Our Ref: SDNP/19/04461/ADJAUT
Contact Officer: Nat Belderson
Tel. No.: [REDACTED]

Neighbouring Authority Consultation

Proposal: A/122/19/OUT - Outline application with some matters reserved for the erection of up to 160 dwellings with public open space, landscaping and sustainable drainage systems (SuDs), vehicular access point from Arundel Road together with up to 557 square metres of B1/B2 units with associated parking provision & vehicular access point from Arundel Road & land made available for expansion of current sports pitch provision to form a sports-hub (following the demolition of existing commercial units and one bungalow) (resubmission following A/36/18//OUT). This application is a Departure from the Development Plan. Address: Land Off Arundel Road, Angmering, BN16 4ET

Figure 5.1: Development Framework Plan.

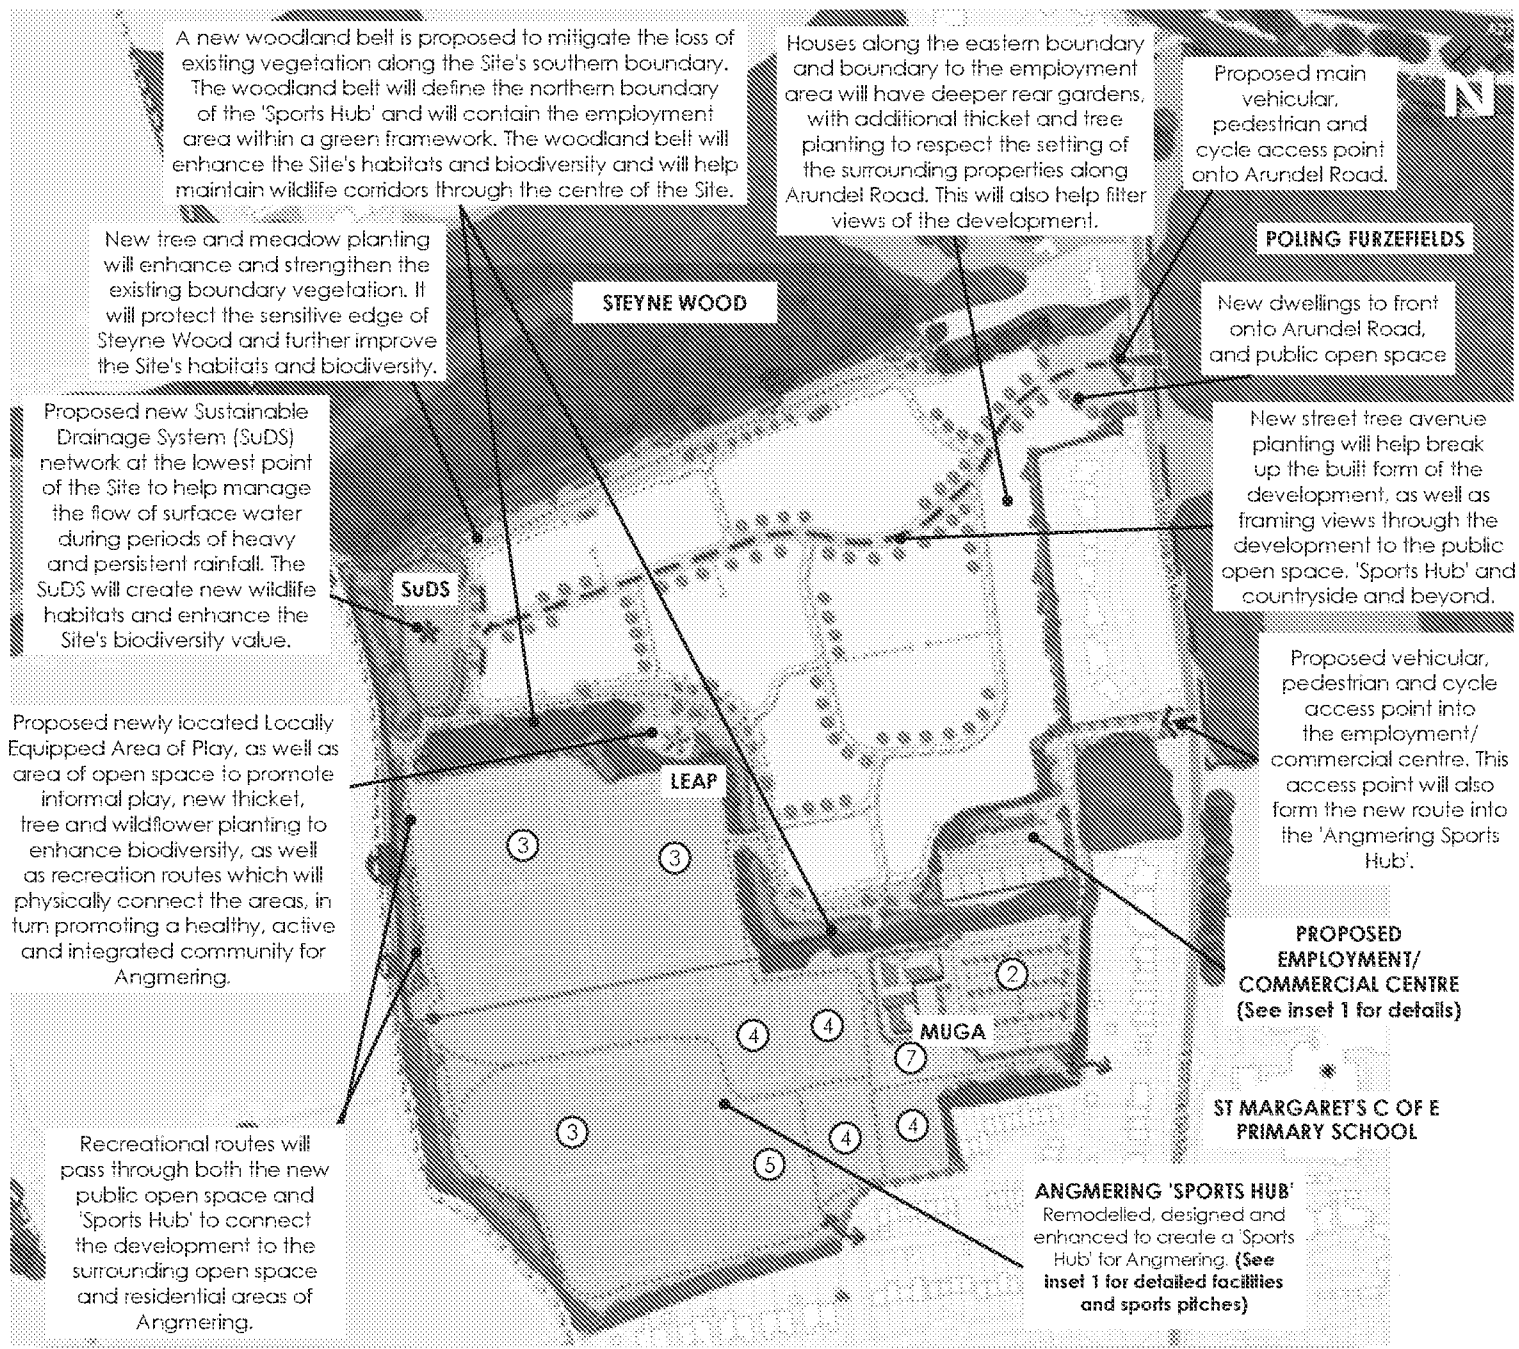
As with the previous application, The masterplan includes a narrow stretch of open space around the perimeter of the site. It is not integrated into the layout of the scheme and does little to connect existing areas of habitat, particularly the surrounding woodland. As currently proposed it has the potential to merely form a circuit for dog walkers and is unlikely to be particularly inviting or an asset for more than the immediate residents. In many places it may be too narrow to provide any opportunities for ecological enhancement.

Figure 5.2: Illustrative Masterplan.

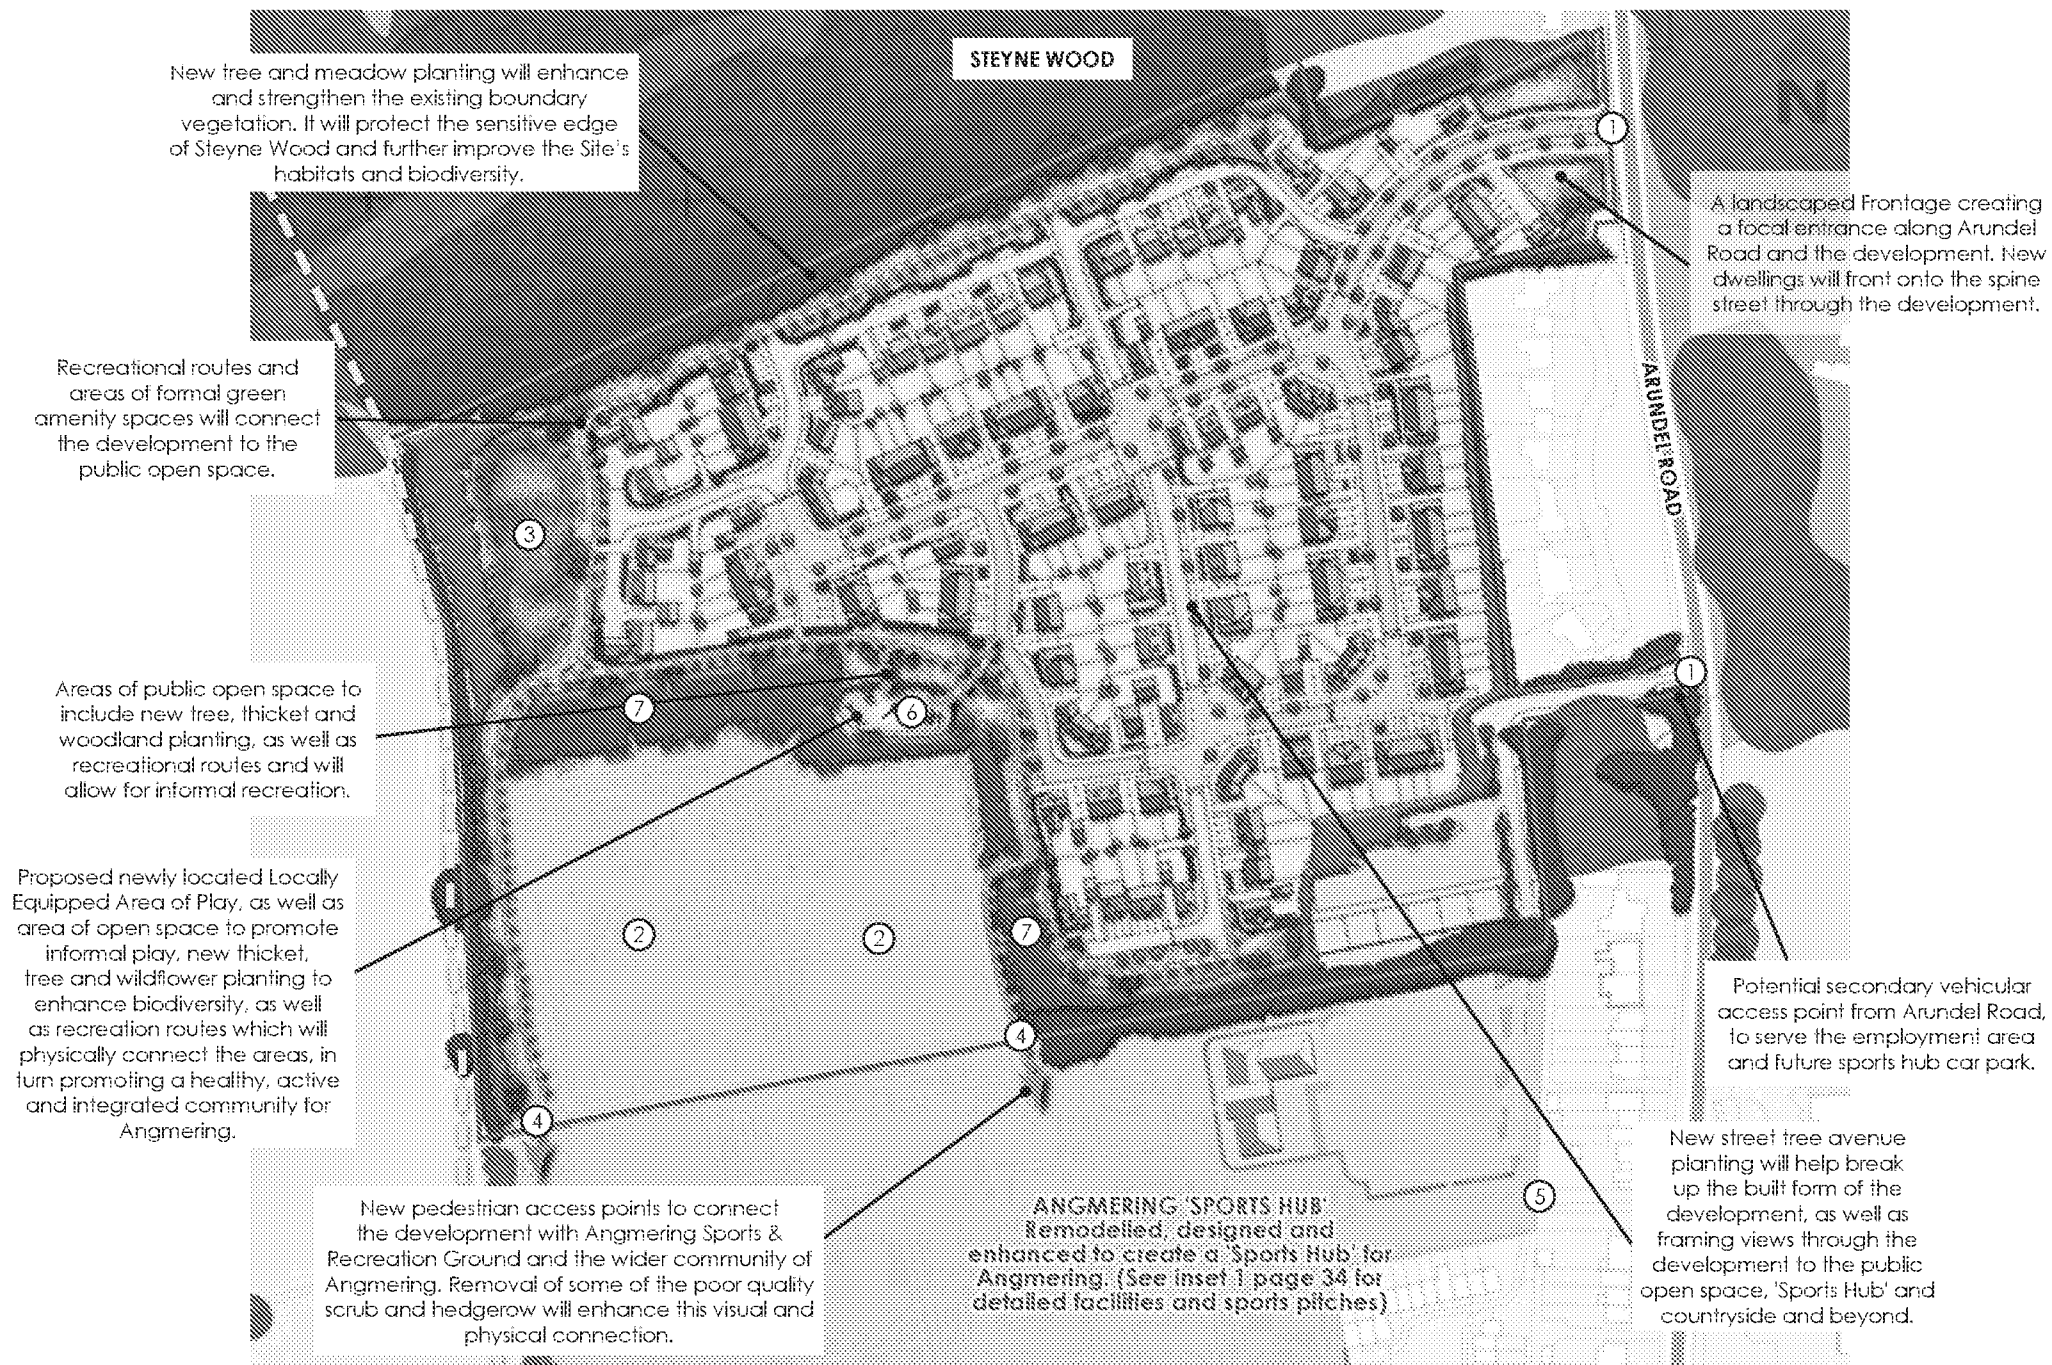
Due to the proximity of the SDNP, we would also encourage the developers to rethink the open space integrating it with the landscape and changes in contours as well as making linkages to the adjoining habitats, particularly the woodland. This is an opportunity to bring the National Park to the existing and new residents of Angmering.
